Re: ICON Samson 10 – 1 Screen Addition 13120 Central Ave, SE Albuquerque, NM  
87123 (COA Drainage # L22/D013A) Temporary Certificate of Occupancy Request

This letter is in support of obtaining hydrology approval for a temporary Certificate of Occupancy associated with the subject property.

PROPOSED
GRADING &
DRAINAGE
PLAN

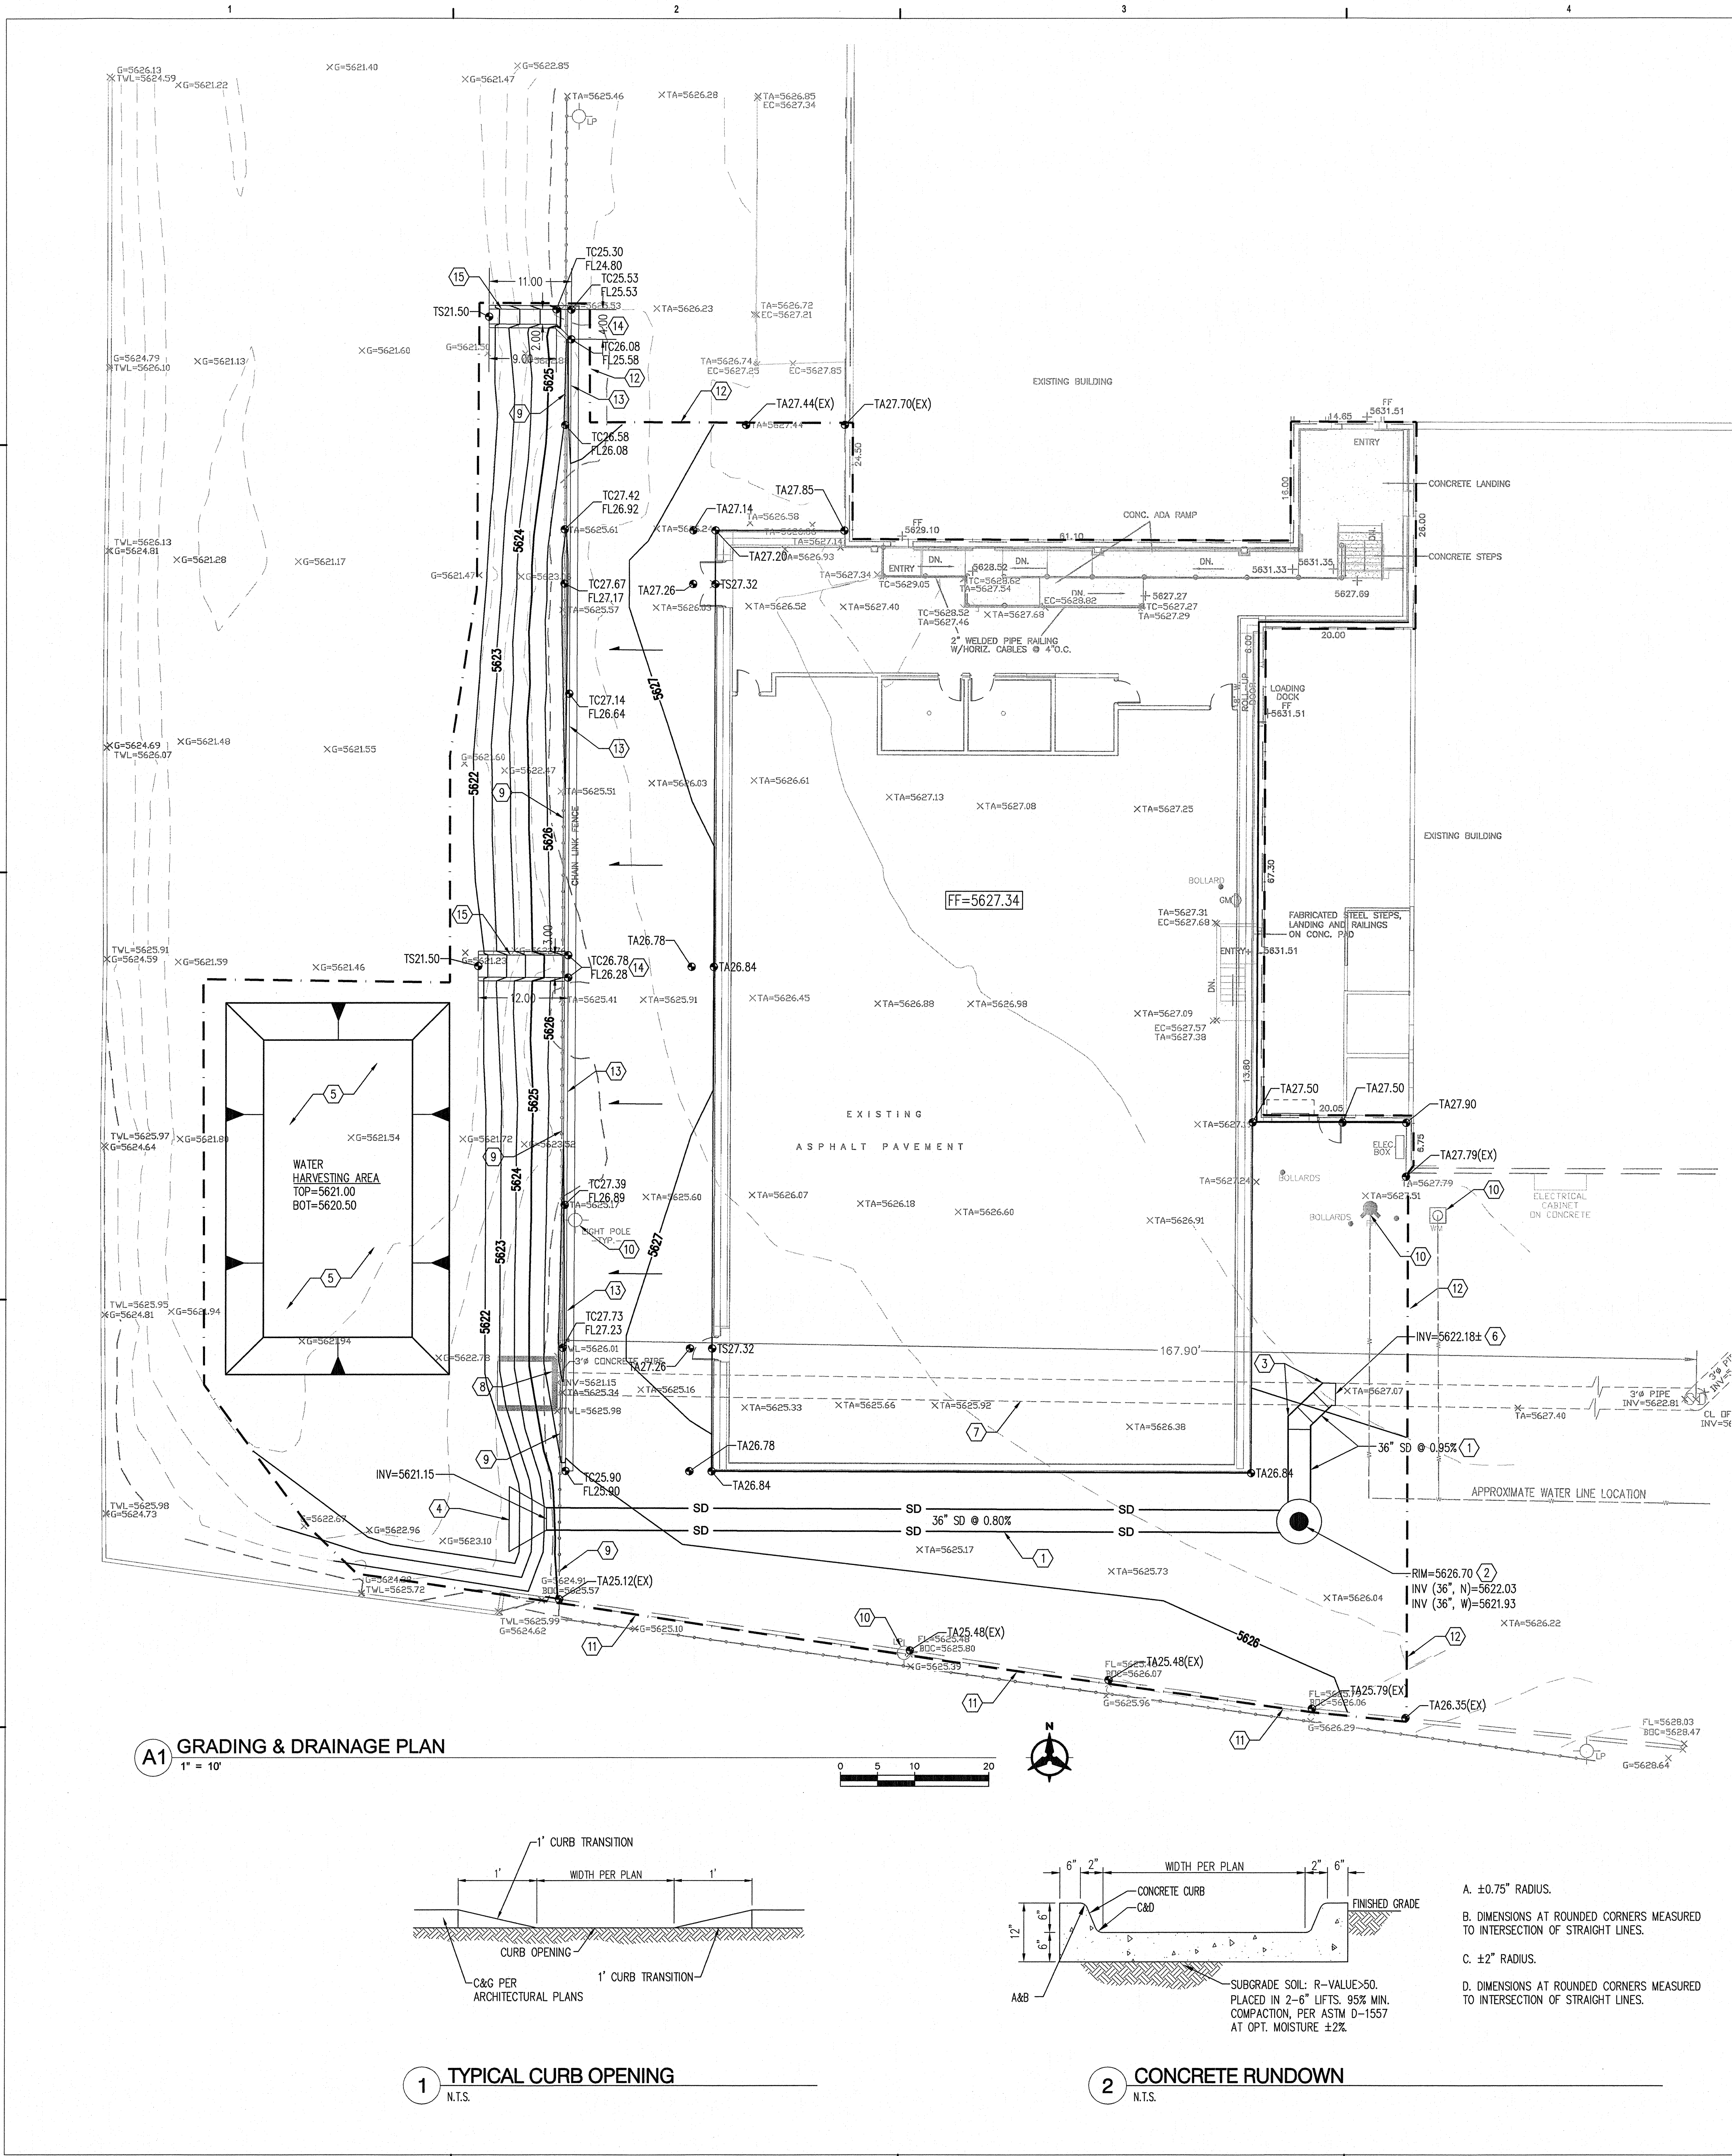
1. An asbuilt survey by a professional surveyor needs to be completed to verify that constructed grades adhere to the approved grading and drainage plan.

2. A drainage certificate per the DPM checklist is required and shall be submitted.
3. As noted within the COA approval letter dated 6-16-2016, erosion protection at the bottom of the pond where rundowns are located needs to be completed.

4. The curb along the drive aisle and rundowns at the low spots needs to be constructed.
5. The water harvesting area within the pond needs to be constructed and asbuilt built grades provided to ensure it meets the design intent.

6. The roof drains for the new building were piped into the pond via two new PVC pipes, in lieu of surface flow and the pipes need to daylight in a concrete rundown down into the pond.

7. The gutter from the roof drain needs to be connected directly to the new storm drain pipe near the building.
8. The new storm drain manhole located on the 36" SD at the south end of the site needs to be uncovered and a new rim and collar needs to be installed per the NMAPWA Standard drawing 2101.

9. The HDPE end section of the 36" pipe needs to be cleaned of all debris and sediment to allow free discharge into the pond.
10. Fine grading in the pond needs to be completed around the outlet structure to ensure positive drainage to the new water harvesting area.
